STATE OF WASHINGTON
DEPARTMENT OF ECOLOGY

January 2, 2019

RE: Comments for Vantage PUD Shoreline Substantial Development Permit

Thank you for providing the Department of Ecology (Ecology) the opportunity to review the revised critical area report and supplemental information for the Vantage Bay PUD Substantial Development Permit application.

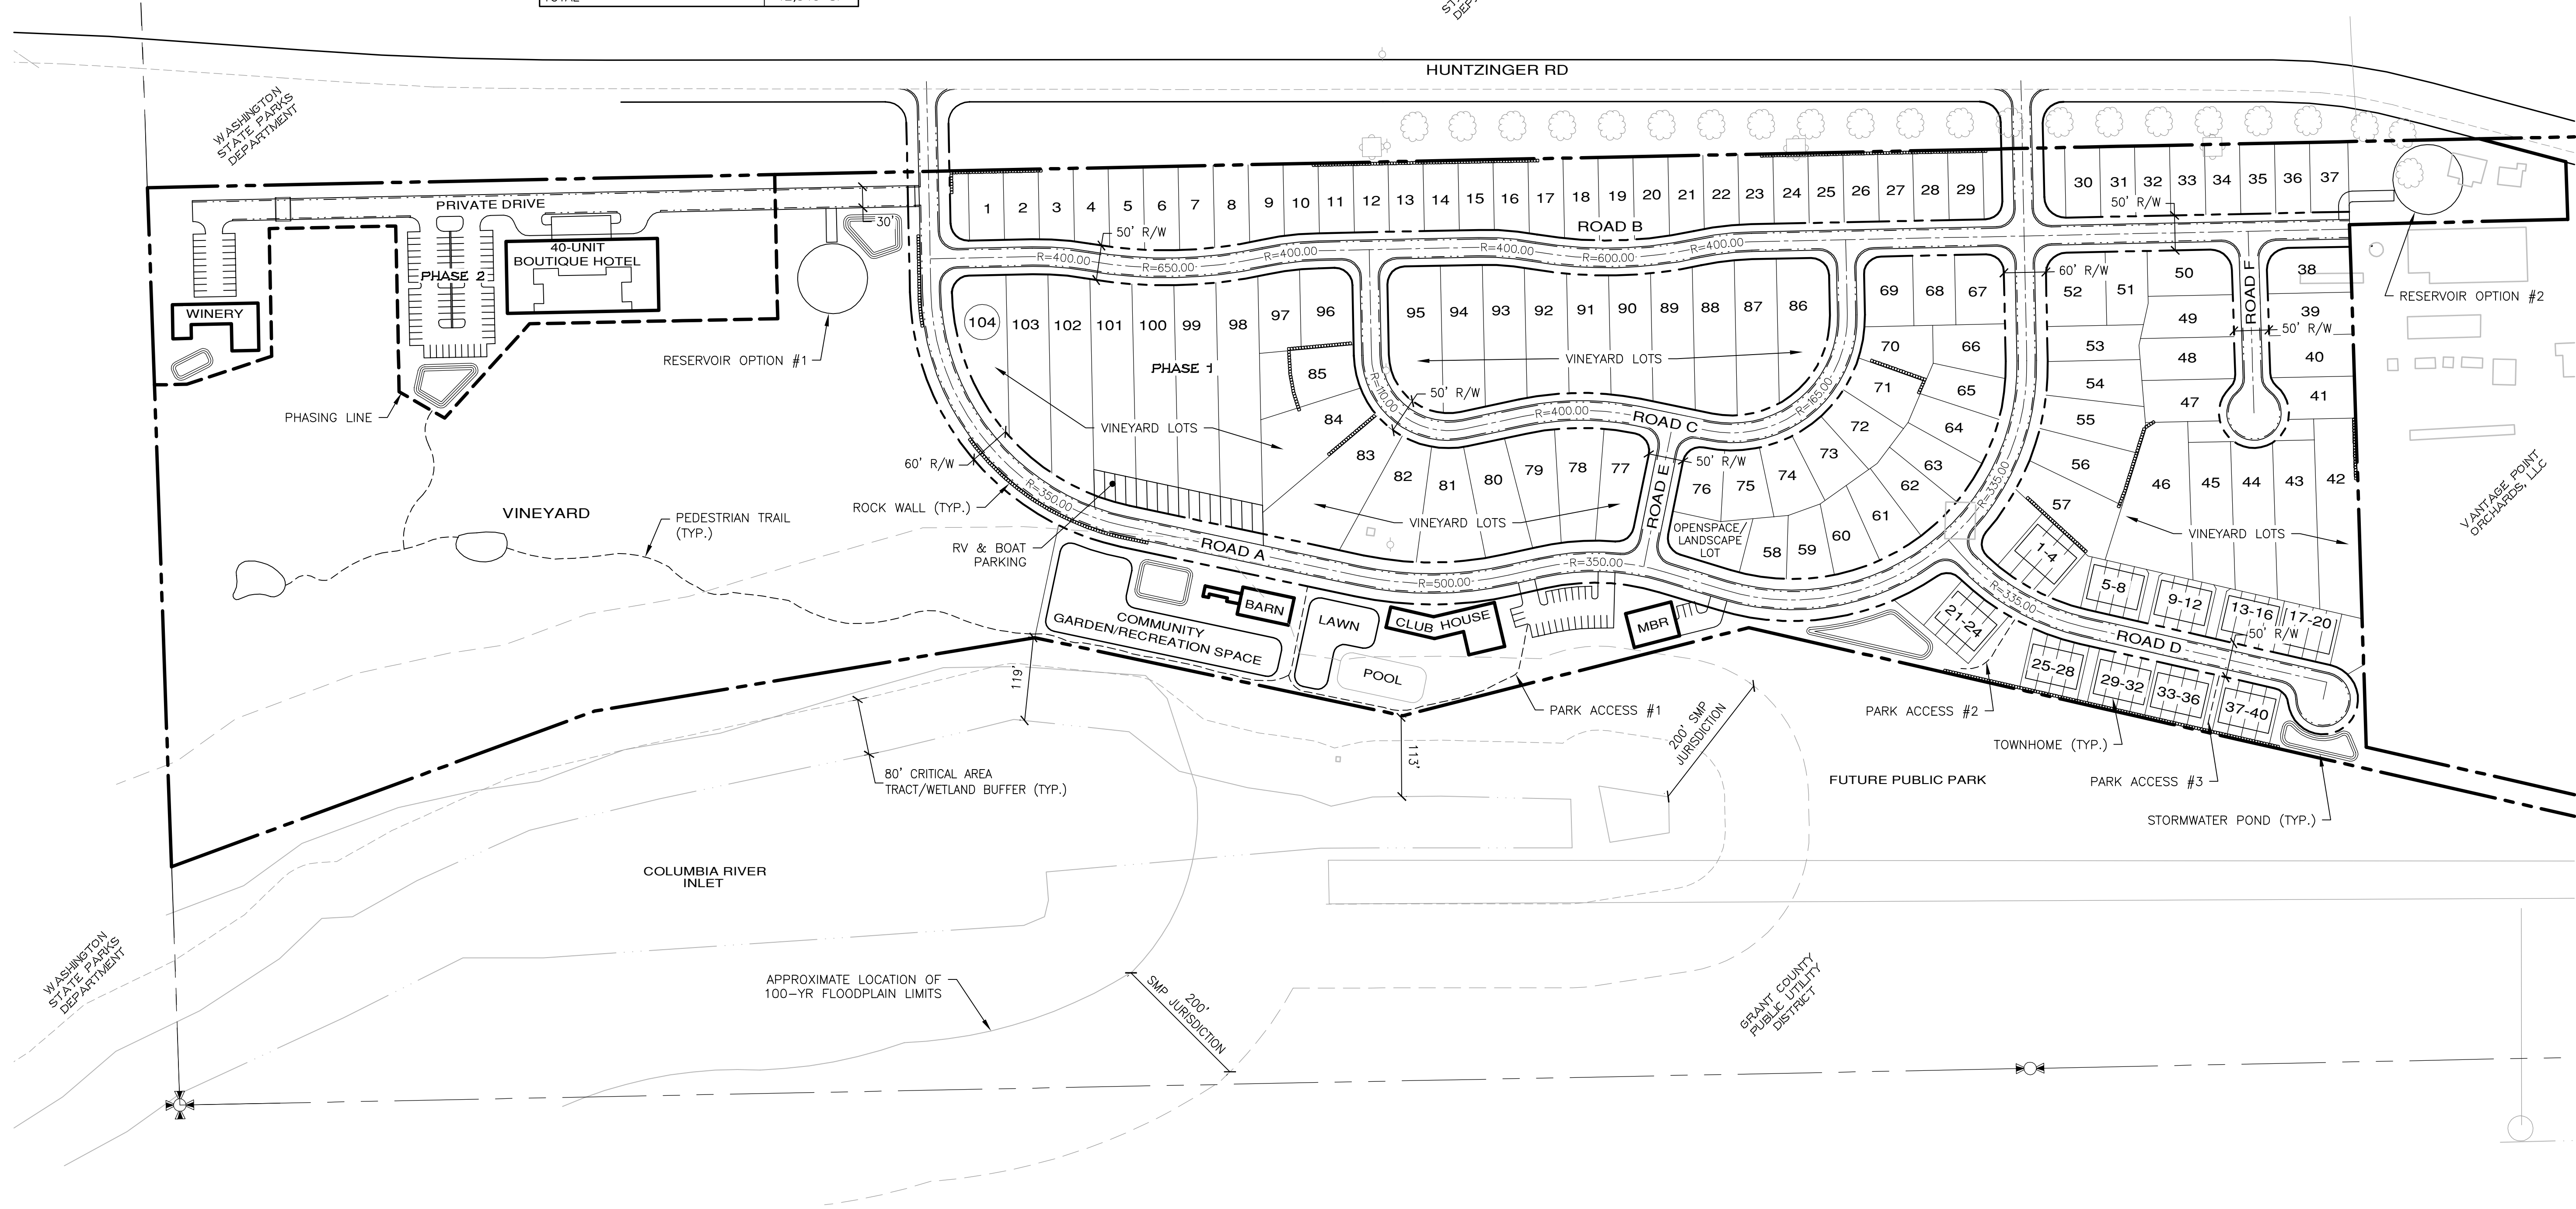
According to the recent submission, the project is located within 126 feet of the wetland boundary. The revised critical area report did not provide wetland boundaries, wetland delineation data sheets, nor wetland rating forms for review and verification. Within the report, the wetland is listed as either a category II or III wetland. The report stated the wetland “was not officially rated or delineated during 2017 using the Washington State Wetland Rating System for Eastern Washington 2014 Update.” According to the Approval Ordinance from 2006, the wetland was rated as a category II wetland. The category of wetland habitat within or adjacent to the project site should be rated in order to determine the appropriate County regulated buffer width.

Plan sheets show an 80’ wide buffer surrounding the potential category II or III wetland. Per the Approval Ordinance from 2006, a *minimum* 80’ wide buffer is to be maintained from wetlands. According to Section 5.2(G), Table 5.2-1, Wetland Buffers for Wetlands in Shoreline Jurisdiction, wetland buffers for category III wetlands surrounded by high intensity use and development are to have a minimum of 150 feet wide buffer (200 feet for category II).

As the project is currently proposed, wetland buffer impacts are likely. With the information provided and the requirements of the County’s SMP, the County should request a new wetland delineation and rating be conducted for the project site.
